**Verrill Dana Interior Renovations
16001
ADDENDUM # 1
ISSUE DATE: October 10, 2016**

ADDENDUM #1

This addendum provides clarifications, additions and design changes to the architectural, structural, mechanical and electrical "Issued for Construction" drawing set issued on 09-21-2016.

A11.2

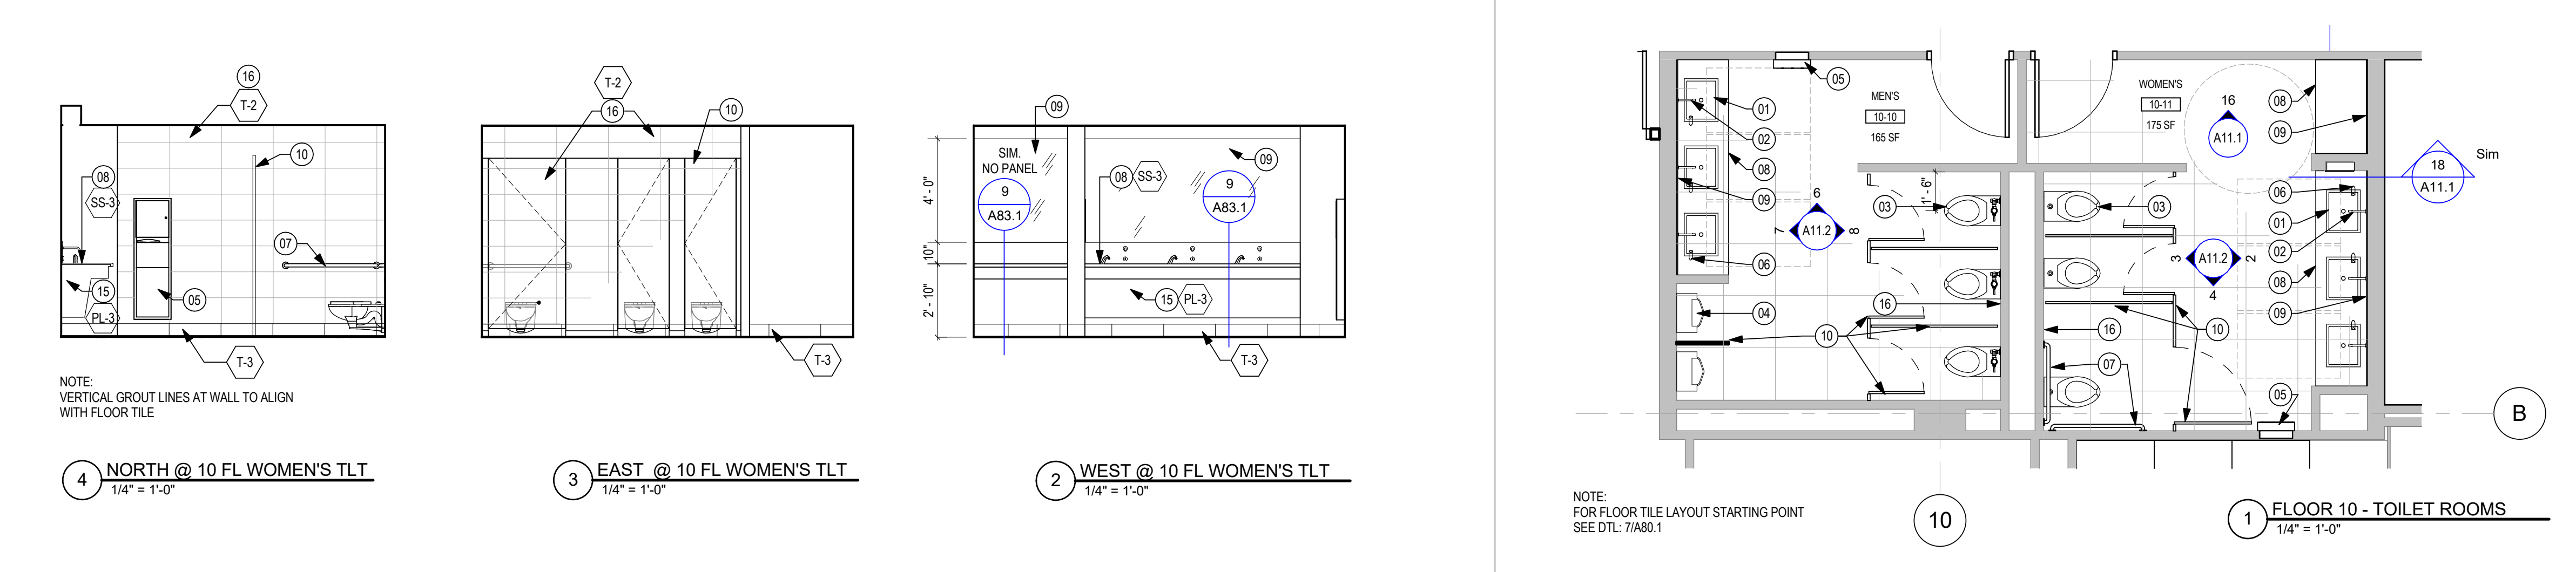
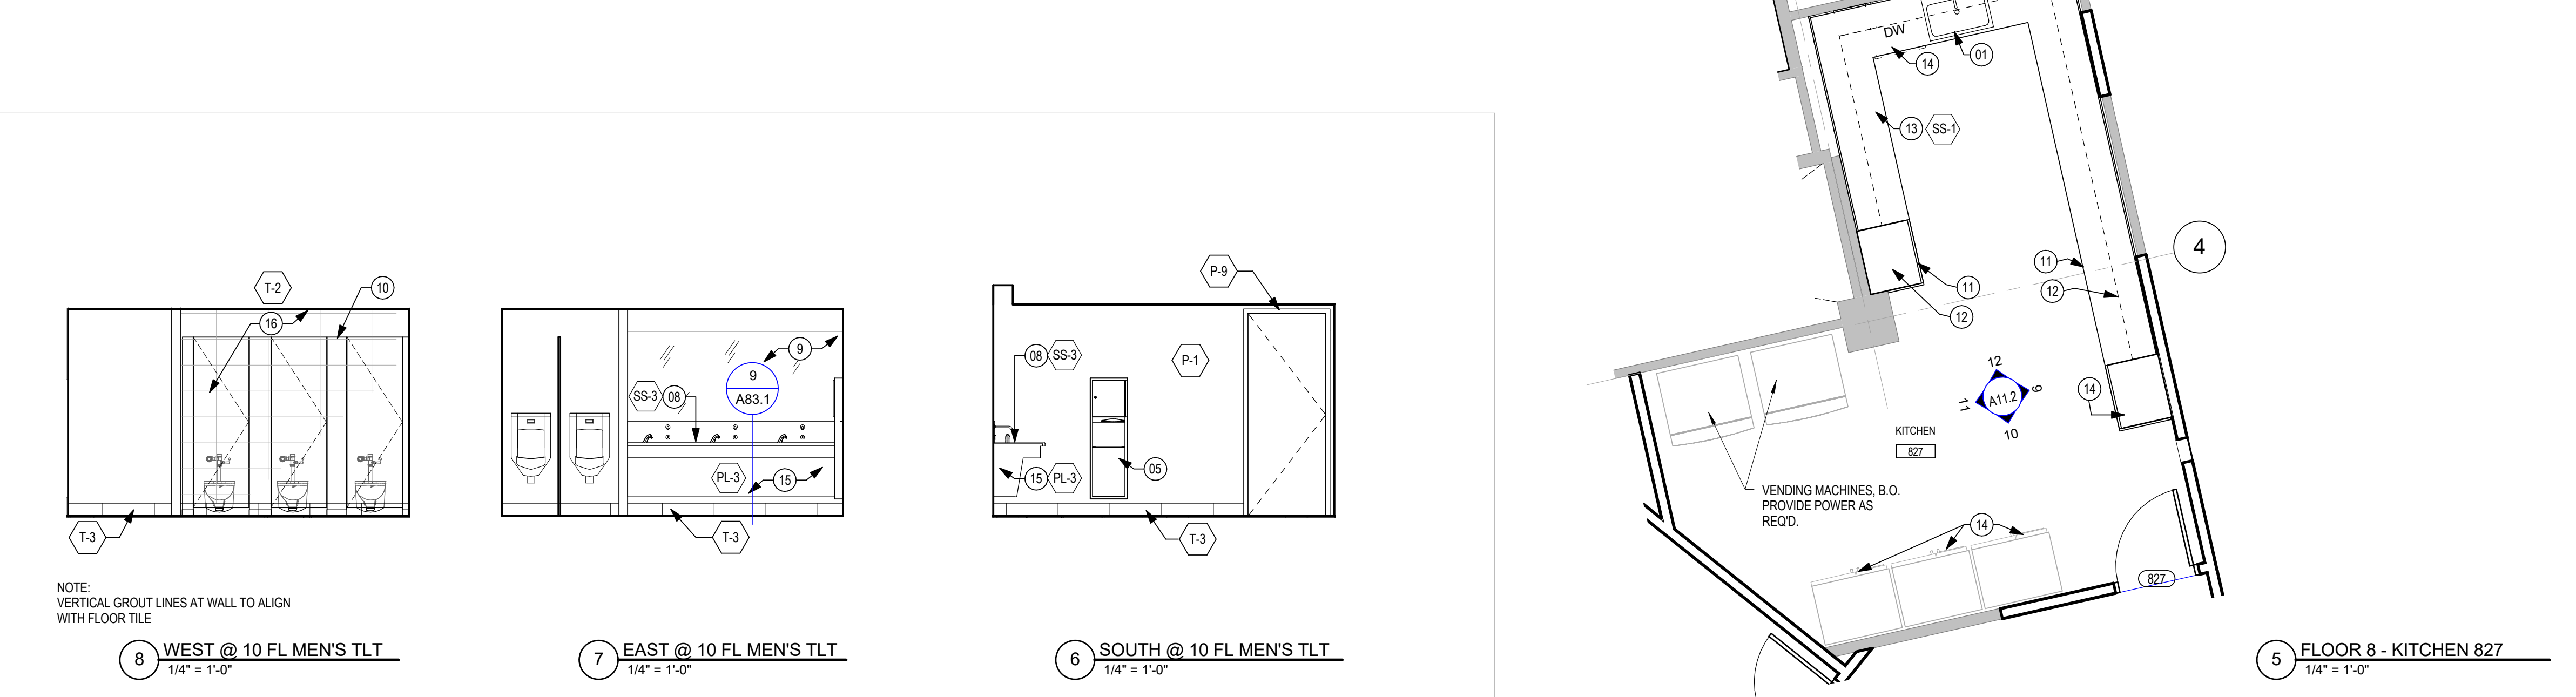
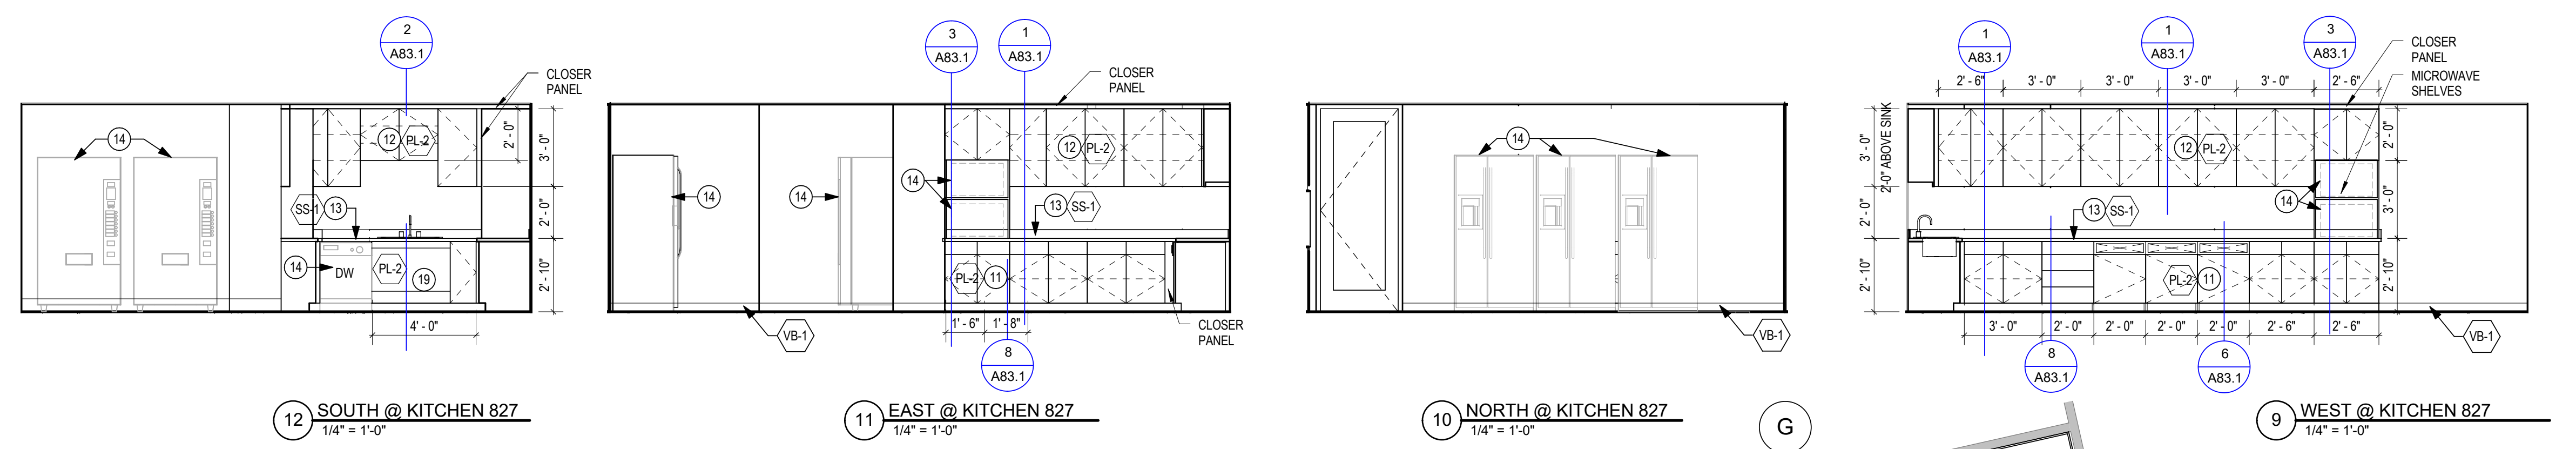
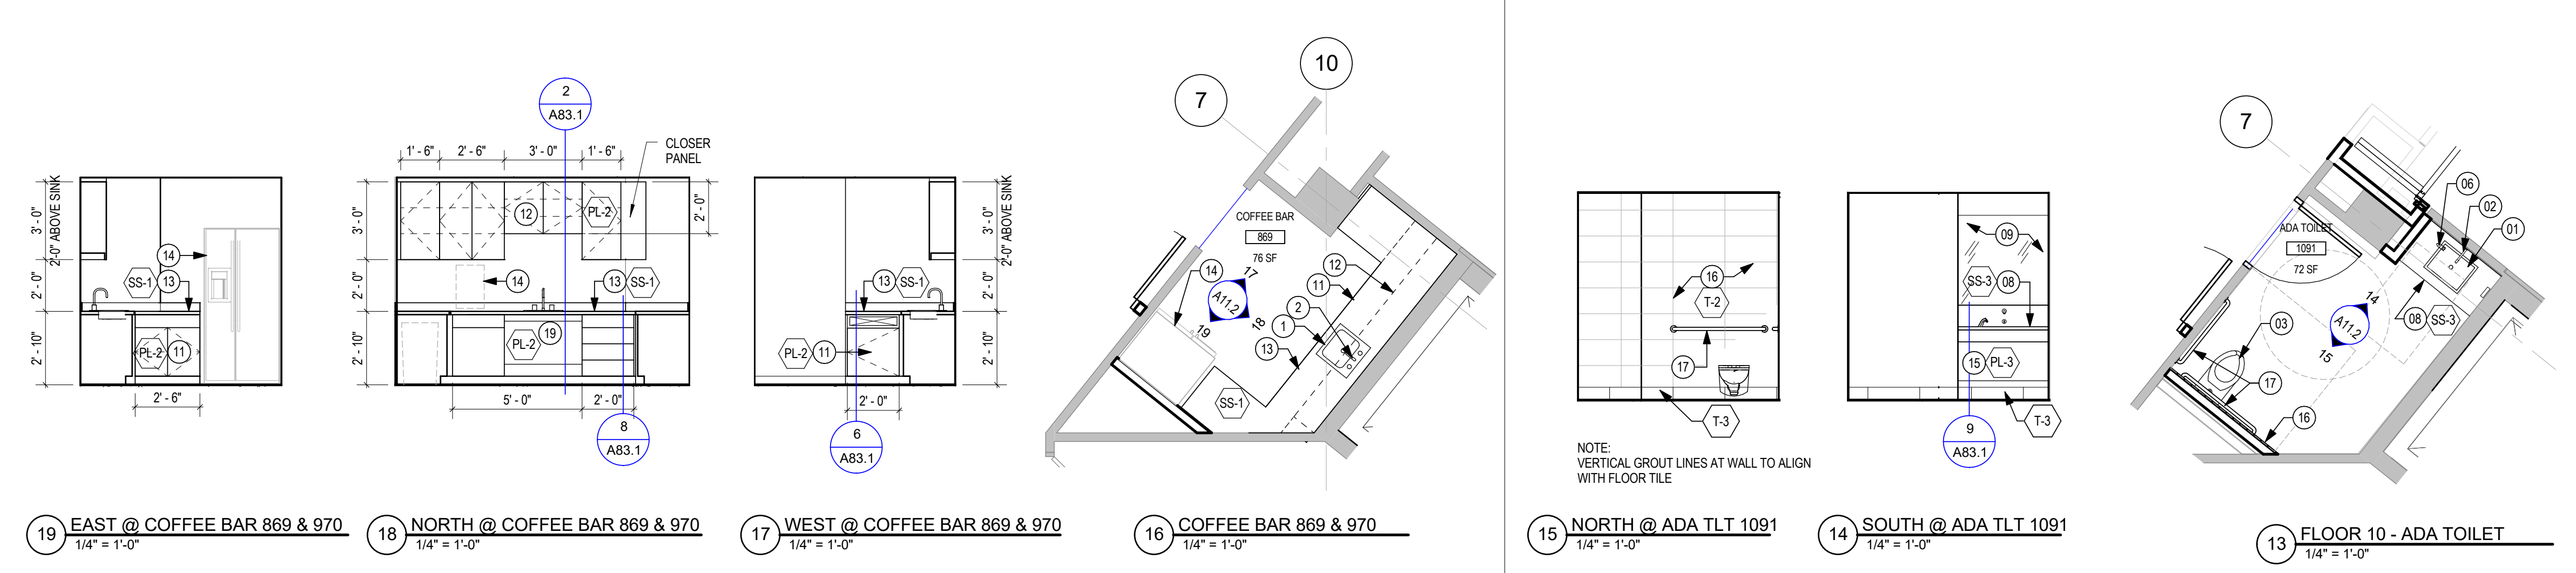
- On sheet A55.1 door elevations on details 7 (door #855C), 14 (door #990A) and 17 (door #9-01A) to be type "G".
- On sheet A11.2, detail 13 add paper towel dispenser/waste receptacle to toilet room #1091.

1 FLOOR 7 FINISH PLAN
1/8" = 1'-0"

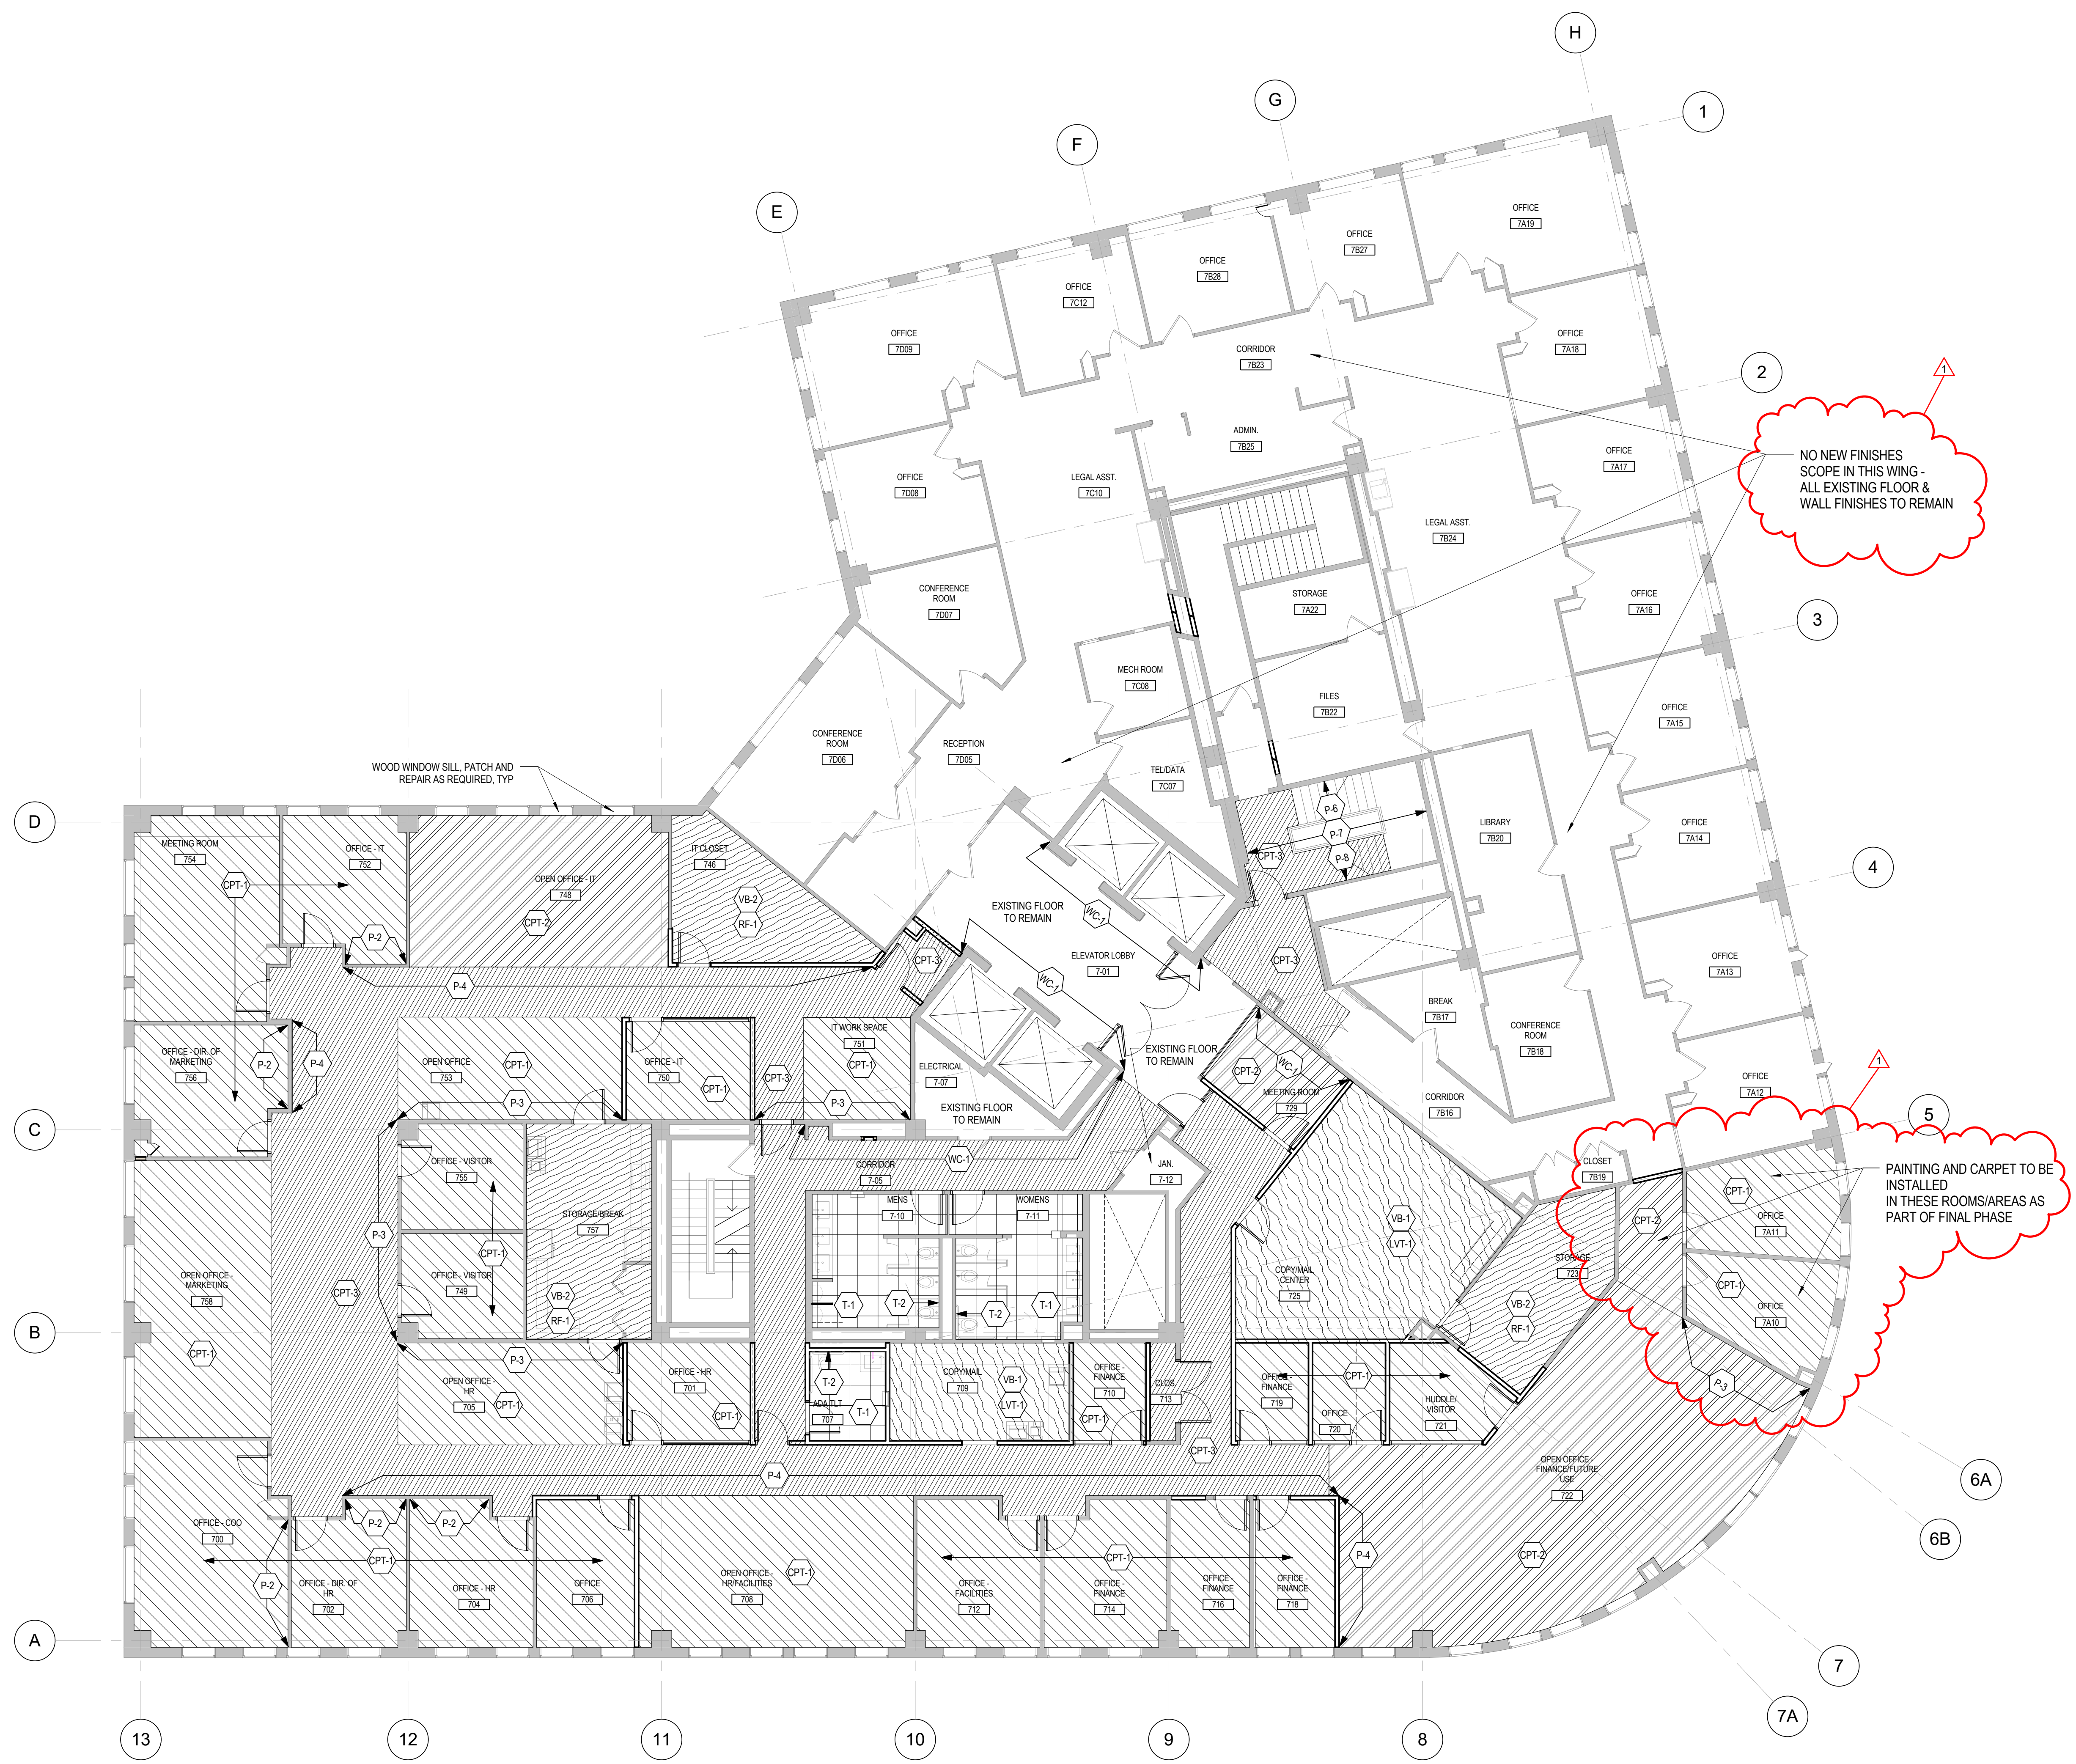
3. Are we to remove the flooring in the stairwell/hallway in the 7th floor? It's not clear if we are to remove only the 3 doors and small amount of walls. Yes. 7th Floor stairwell/Hallway to receive CPT-3 per finish plan.
